Recommendation Report for Planning Permission for Works or Extension to a Dwelling

REF NO: AL/35/19/HH

LOCATION: Ashmead
Fontwell Avenue
Eastergate
PO20 3RU

PROPOSAL: Single storey rear extension and addition of 1st floor with alterations to fenestrations and internal alterations.

Proposed Front Elevation (east)

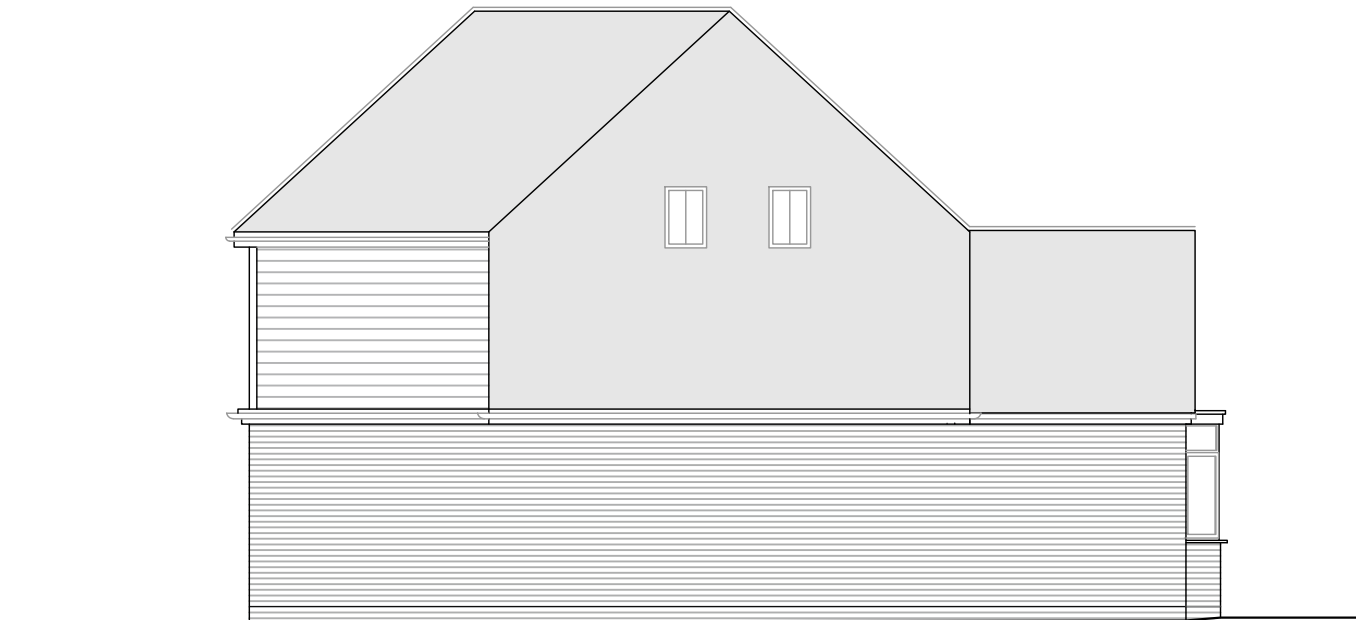
The proposal will increase the ridge height of the dwelling by approximately 2.5m. Eaves will remain as existing. There will be a hipped roof which will follow the slope of the existing roof as the ridge increases. To the front there are 2 gables projections. 1 of these will remain as existing with the other constructing a first floor above increasing the height from 4.85 to 7.3m. Whilst this increase is large as a result of the siting in relation to the neighbouring windows at the north, it is not considered to provide any adverse overbearing or overshadowing with 6m to the boundary.

Proposed Side Elevation (north)

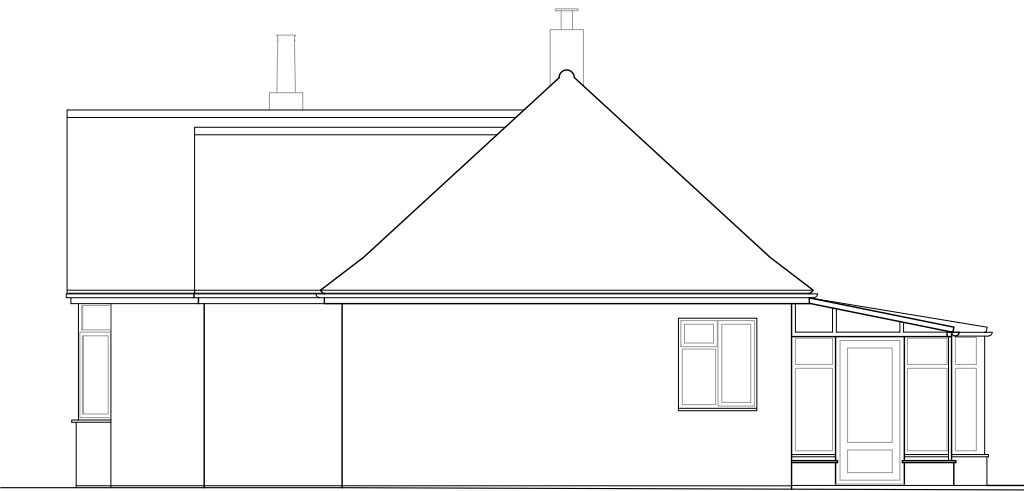
There will be 3 windows to the ground floor north elevation and with them at ground floor level they are not considered to give rise to adverse overlooking with boundary treatment and sufficient separation in place. There are 2 velux proposed to the first floor bathrooms at the northern and southern elevation and due to their position in the roof slope and their siting at a minimum of 1.7m height above internal floor level they are not considered to provide adverse overlooking.
